CCS Response to Applicants Response to Examining Authority's Second Written Questions

60586176-BR-DRG-006-0
 Bridge Elevation and Long Section

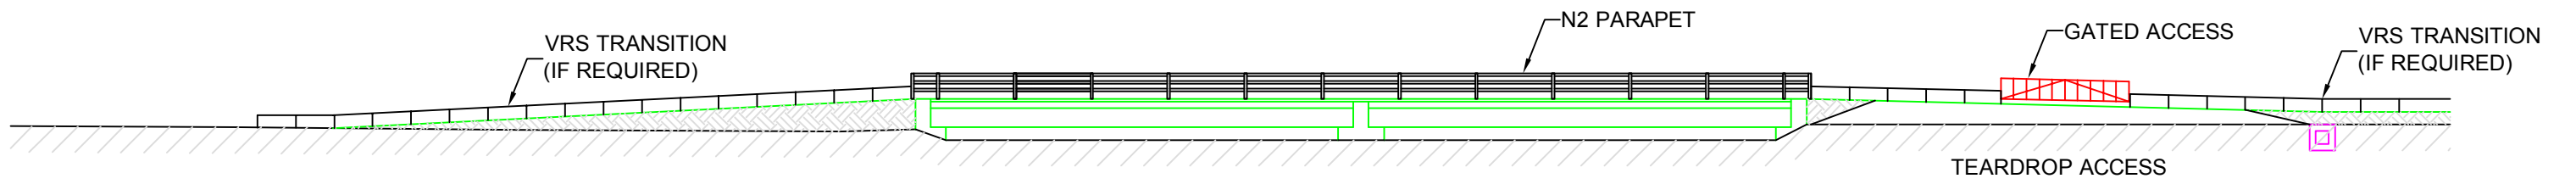
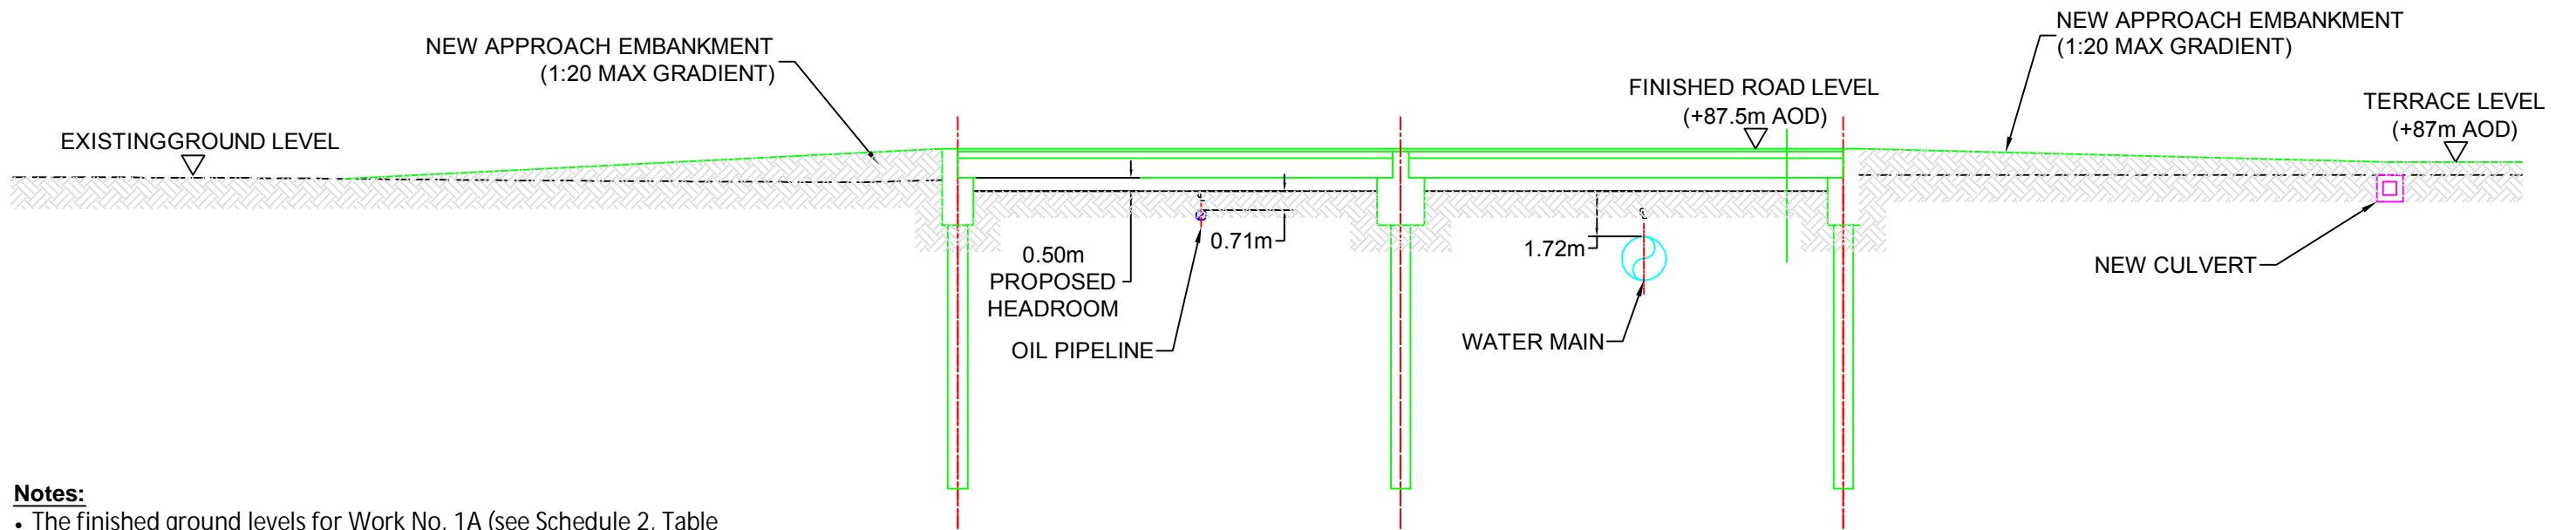
<p>2.7.4</p>	<p>Crossings:</p> <p>“The draft DCO submitted for Deadline 4 has been updated to include parameters for the design of the road structure crossing the Welsh Water water main, see Schedule 2 Table 3 of the updated draft DCO, submitted at Deadline 4.”</p>	<p>CCS doesn't have any substantive issues with regards to the parameters include in Table 3 but have sought clarification on whether the maximum height of the structure includes the barrier height.</p> <p>CCS would also query whether the water main crossing structure needs to be explicitly set out in Work No. 2 of Schedule 1 as it is not defined within the Authorised Development and Table 3 refers back to the Authorised Development.</p>
<p>2.7.5</p>	<p>Requirement 9:</p> <p>“New habitats are being created to compensate for the loss of habitats during the construction phase of the Project. The newly created habitats will be monitored to feed into the management of the habitats to help ensure the successful establishment and ongoing functioning. While the newly created habitats will support a number of species, they are not being created solely for the purpose of species mitigation. The monitoring and management of newly created habitats is secured by the LEMS, and compliance with the approved ecological management plan and any timetable included is set out in Requirement 9(2).”</p> <p>...</p> <p>“As such, there is no need to include species or habitats monitoring within Requirement 9 Ecological Management Plan.”</p>	<p>CCS maintains that there needs to be a mechanism to ensure that ongoing management and monitoring is in place and is effective for the lifetime of the project and the current omission of a review in Requirement 9 is flawed.</p> <p>Section 4.7.2. of the Outline LEMP sets out the management aims of the LEMP which include:</p> <ul style="list-style-type: none"> • Create, maintain and enhance habitats of value to wildlife to provide benefits for the local environment and biodiversity; • Create marshy habitats in conjunction with the attenuation areas for amphibians and invertebrates (including the marsh fritillary); and, • Establish a flexible management and maintenance regime able to respond to changing needs or objectives. <p>These aims are not secured currently.</p> <p>Section 4.8.2 states that management of habitat enhancement measures during the operational phase will be secured by requirement in the DCO and via appropriate grazing and management agreements but this is clearly not the case.</p> <p>Sections 8.8.36 – 8.8.38 of the ES refer to monitoring and management but these are not secured without a review mechanism included in this Requirement. If there is no monitoring and review, CCS would have no opportunity to seek</p>
